Our ref: Mixed use development with infill affordable housing - Oxford and Verona Street, Paddington (SSD-87245208)

Subject: Request for Additional Information

I refer to the State significant development application for a mixed-use development with infill affordable housing at 13-17 Oxford Street and 2 Verona Street, Paddington (SSD-87245208).

Drawing Title  
**LEVEL 1 FLOOR PLAN**

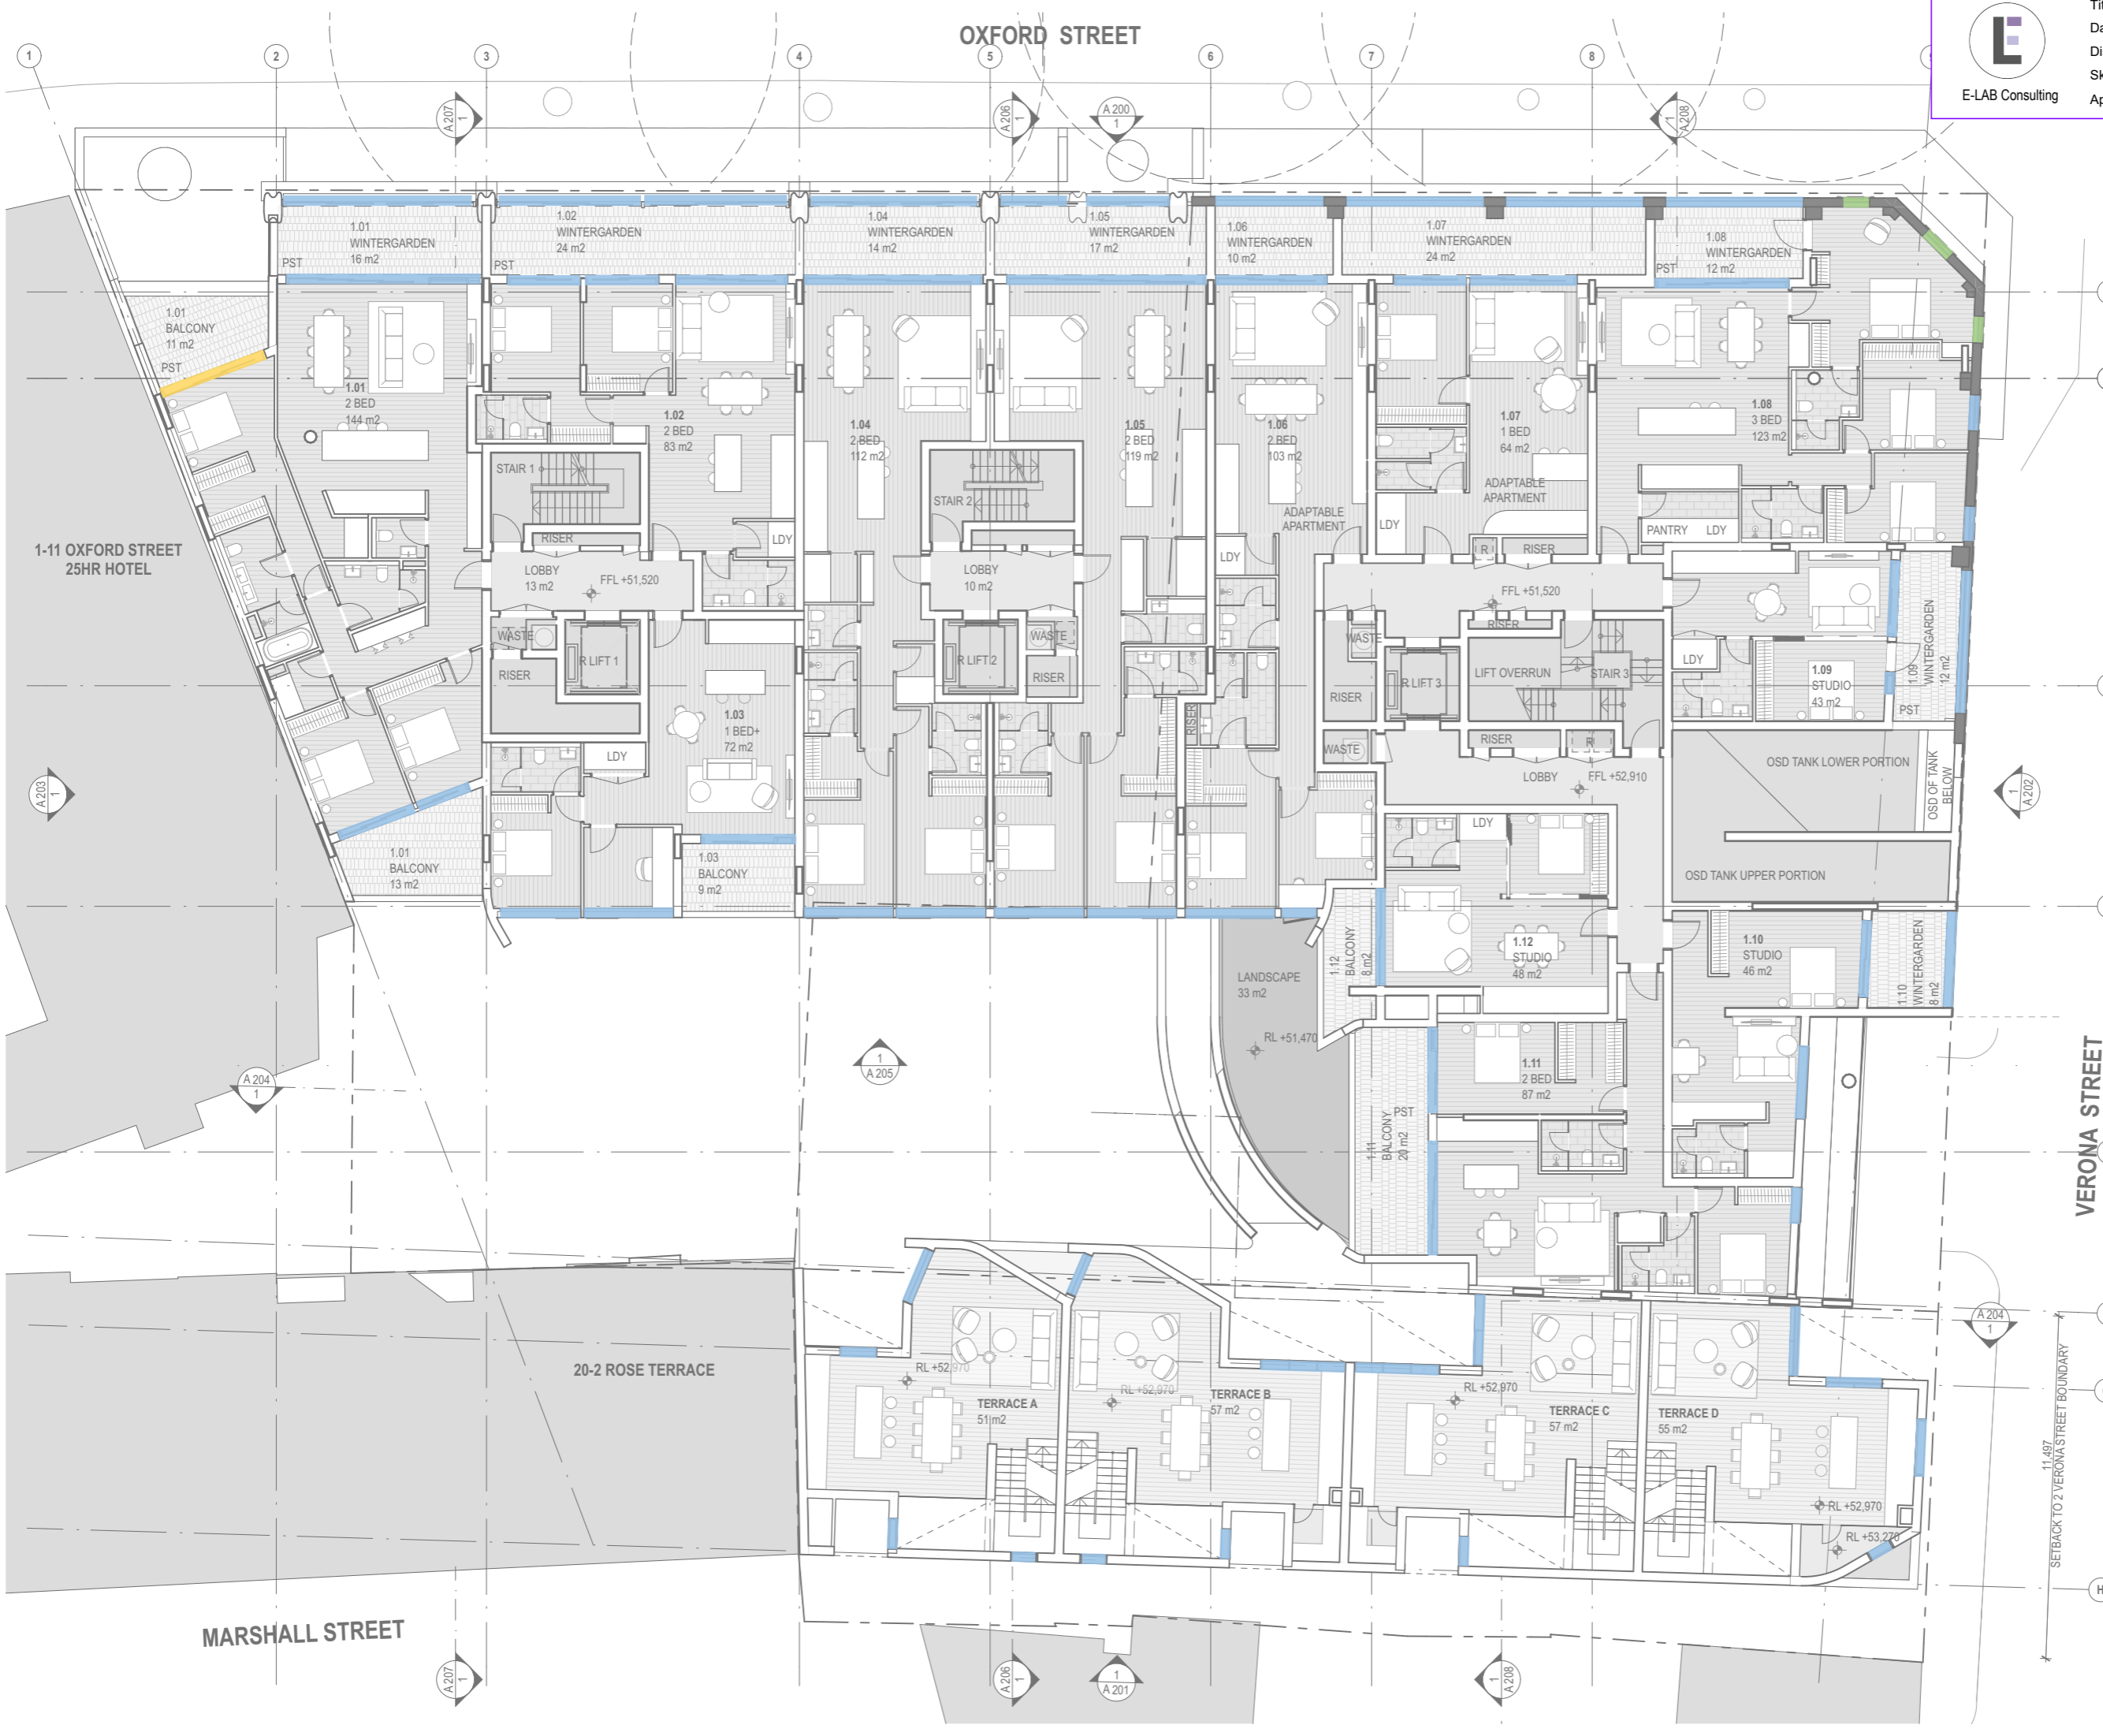
- Architectural plans demonstrate that the wintergarden for Apartment 1.13 (studio) is impeded by a nib wall. Clarify whether this is a drawing error. If not, provide an assessment to demonstrate that the nib wall would not adversely affect the internal and external amenity of the unit.
